Office of  
Environment  
& Heritage

DOC18/169807  
SSD 5093 MOD 4

**Exhibition of Modification for the M2 site, North Ryde Station Urban Activation precinct  
(Lachlan's Line) - SSD 5093 MOD 4**

**Attachment 1 – Office of Environment and Heritage (OEH) comments M2 and North Ryde Urban Activation Precinct SSD 5093 Mod 4**

SAFE ACCESS PROPOSAL (RECOMMENDED. MINOR IMPACT TO BUNDARA RESERVE BUT BEST OVERALL BALANCE)

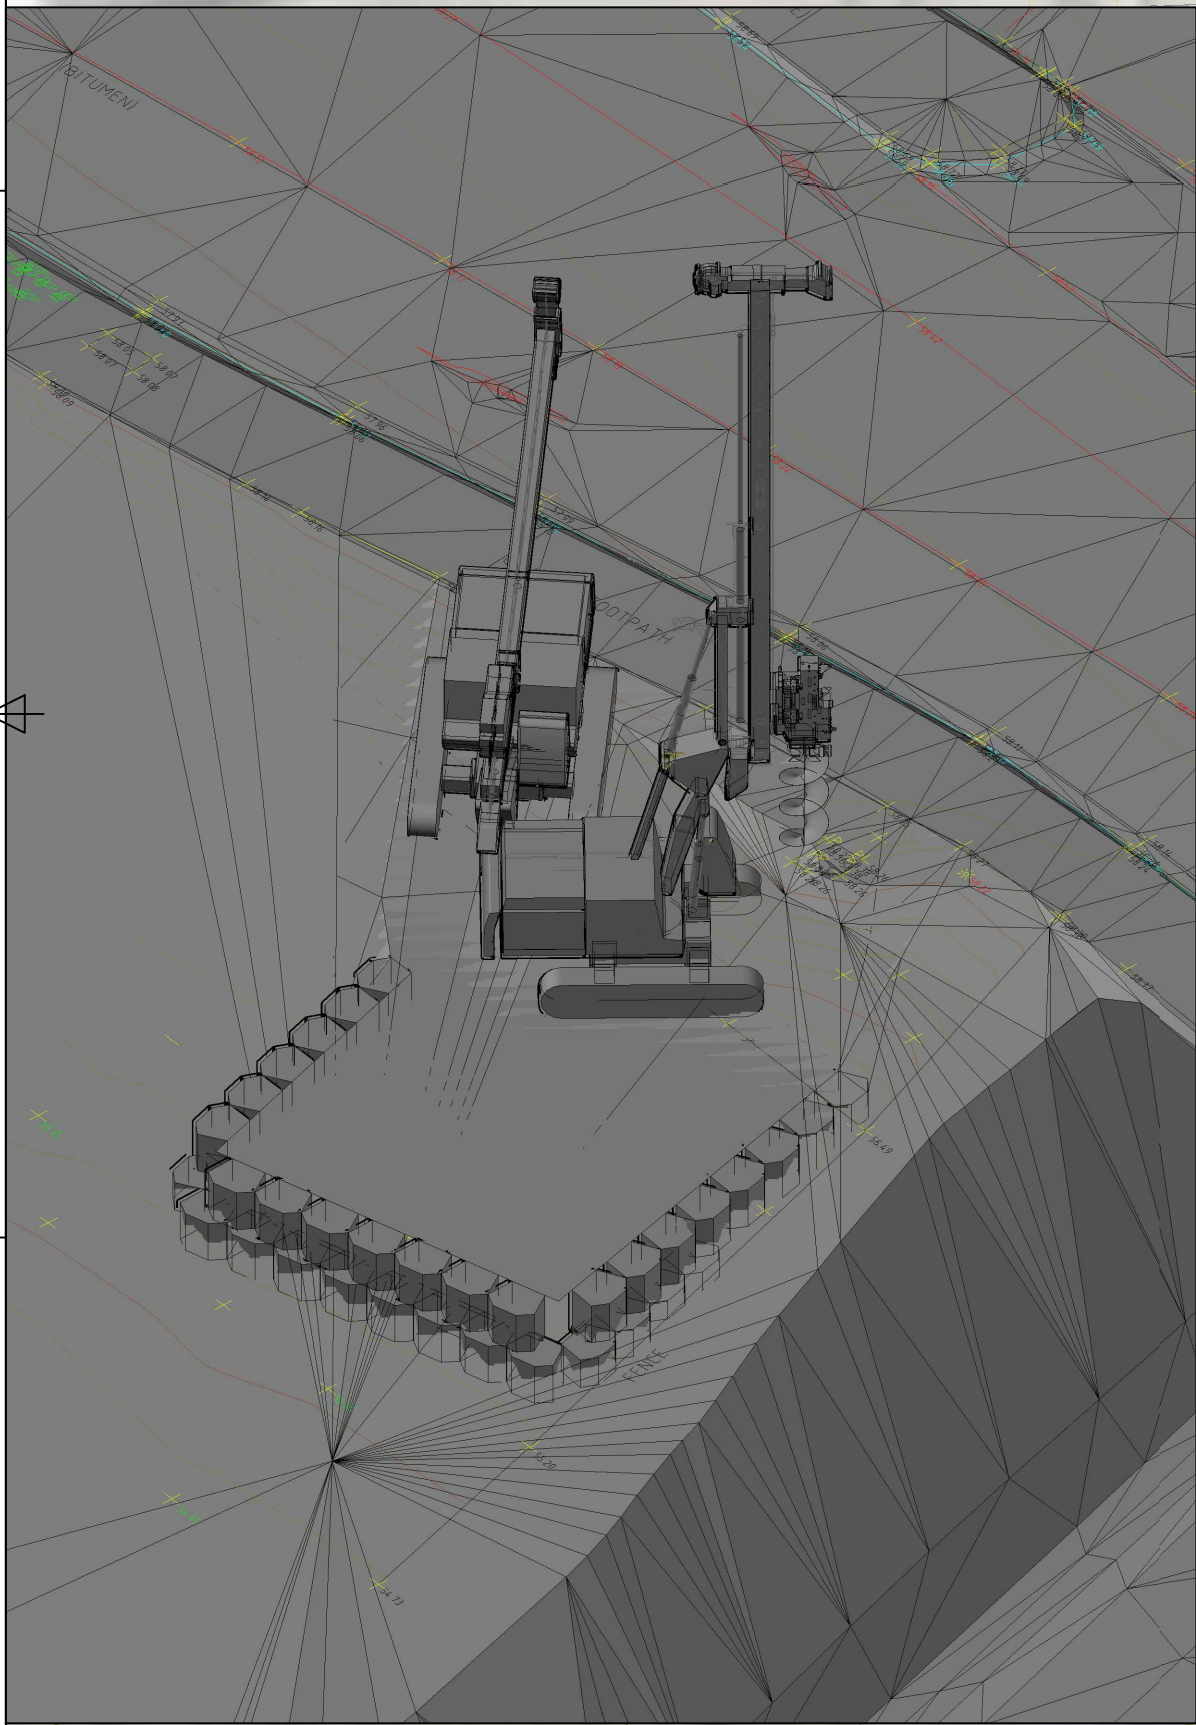
- It is recommended the proponent reassesses whether there is potential to amend the proposed modification to reduce the proposed 5m buffer around the pedestrian bridge footprint to retain STIF and avoid clearing some of the STIF within the area. This would be consistent with the principles of avoid and minimising impacts as per the objects of the BC Act, 2016 which have not been addressed in the current modification. It is noted that 13 trees are proposed to be removed because they are within the 5m offset (buffer area) from the pedestrian bridge, as identified in Section 7 Tree Survey Table of the Arborists report dated October 2017. The reasons given for this buffer are not considered justifiable or reasonable ("minimize tree falls, heat of bushfire on steel and bird droppings and Eucalyptus Oil and leaf litter corroding the paint"). These 13 trees could be retained and eight of these trees are in average to good condition.

- A further, 10 trees are proposed to be removed that are within an area defined as a fall zone should they fall in some unforeseen circumstance and impact on the bridge. These trees are identified due to their heights or potential mature heights. Of these 10 trees, 7 are in average health and only 1 is in poor health and further only two trees are 28m high, with the majority below 10m in height.
